Re: Windroos Nursery, Worthing Road, Littlehampton, BN17 6LY.

Thank you for your recent correspondence advising me of an amended application for the approval of reserved matters for the development of 84 No dwellings at the above location, for which you seek advice from a crime prevention viewpoint.

TITLE PROPOSED SITE PLAN - SHEET 2 OF 2

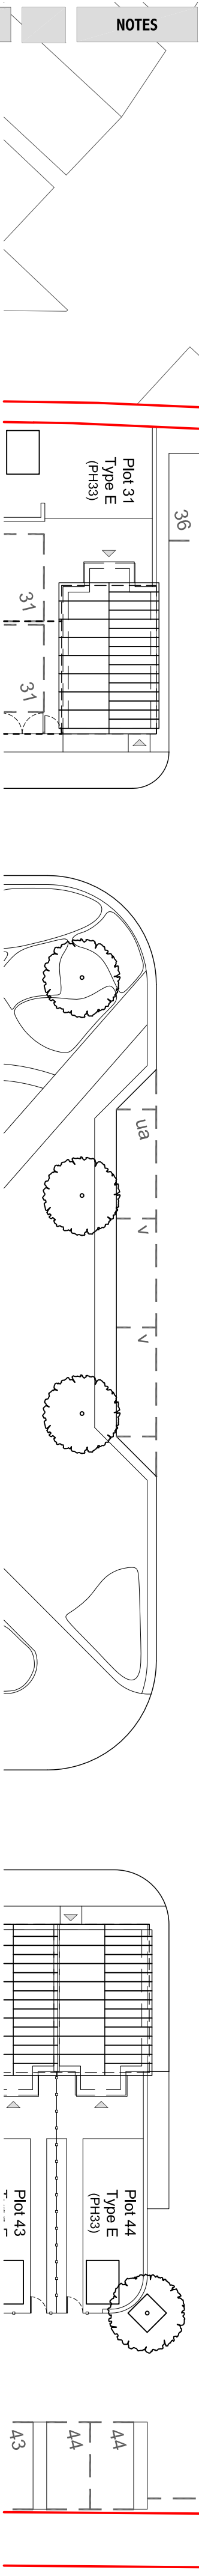
I was pleased to note that the amended Design and Layout has gone a long way to satisfy my concerns regarding unobserved parking.

I note that some rear garden pathway are still present. Therefore I would to reiterate my advice about the fencing configuration. Gardens overlooking a rear access garden path should be a combination of 1.5 metre high close board fencing topped with 300mm of trellis. This arrangement will provide a security height of 1.8 metres but will also allow a degree of surveillance into an otherwise unobserved area.
